Application for a Non-Material Amendment Following a Grant of Planning Permission

Number	5
Suffix	
Property Name	
Address Line 1	Dovecot Close
Address Line 2	
Address Line 3	Hillingdon
Town/city	Eastcote
Postcode	HA5 2RE

Erection of single storey extension to the rear and conversion of integral garage to habitable accomodation

56655/app/2023/1337

B. PROPOSED REAR ELEVATION

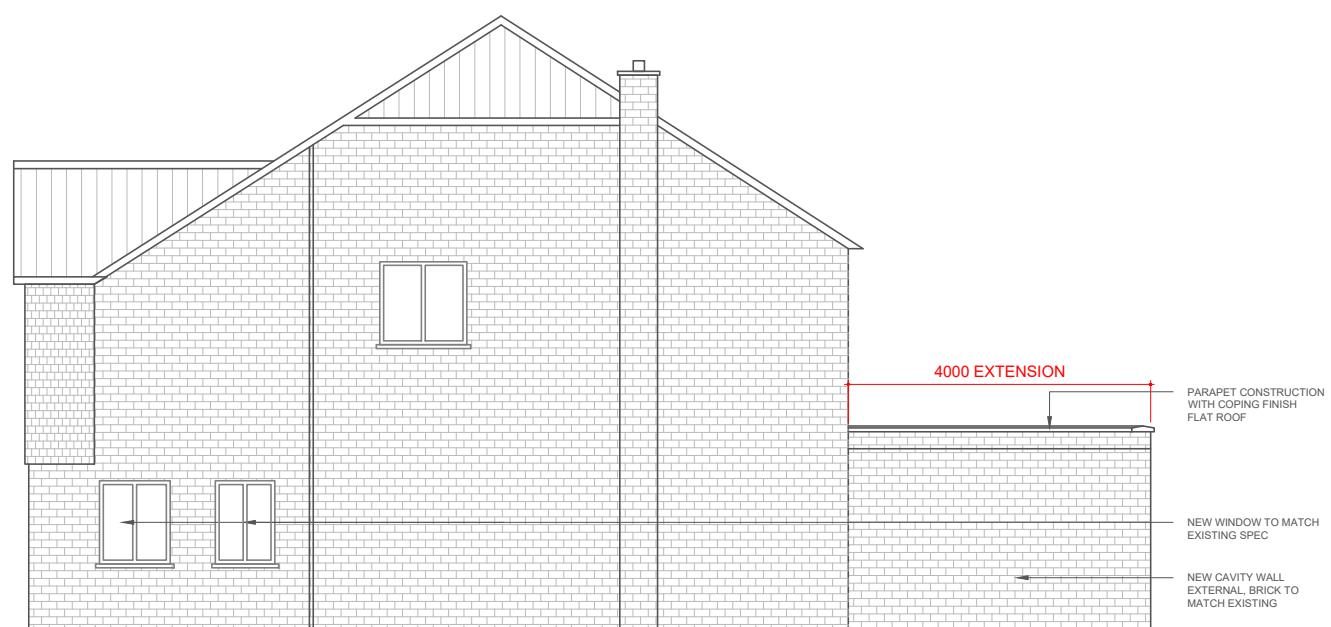
Minor amendment being alterations to fenestration on single storey rear extension pursuant to planning permission 5665/APP/2023/1337 for Single storey rear extension.

The proposal to omit the window and the door for new larger bifolding door to allow natural lighting into the property.

Proposed Elevation P3
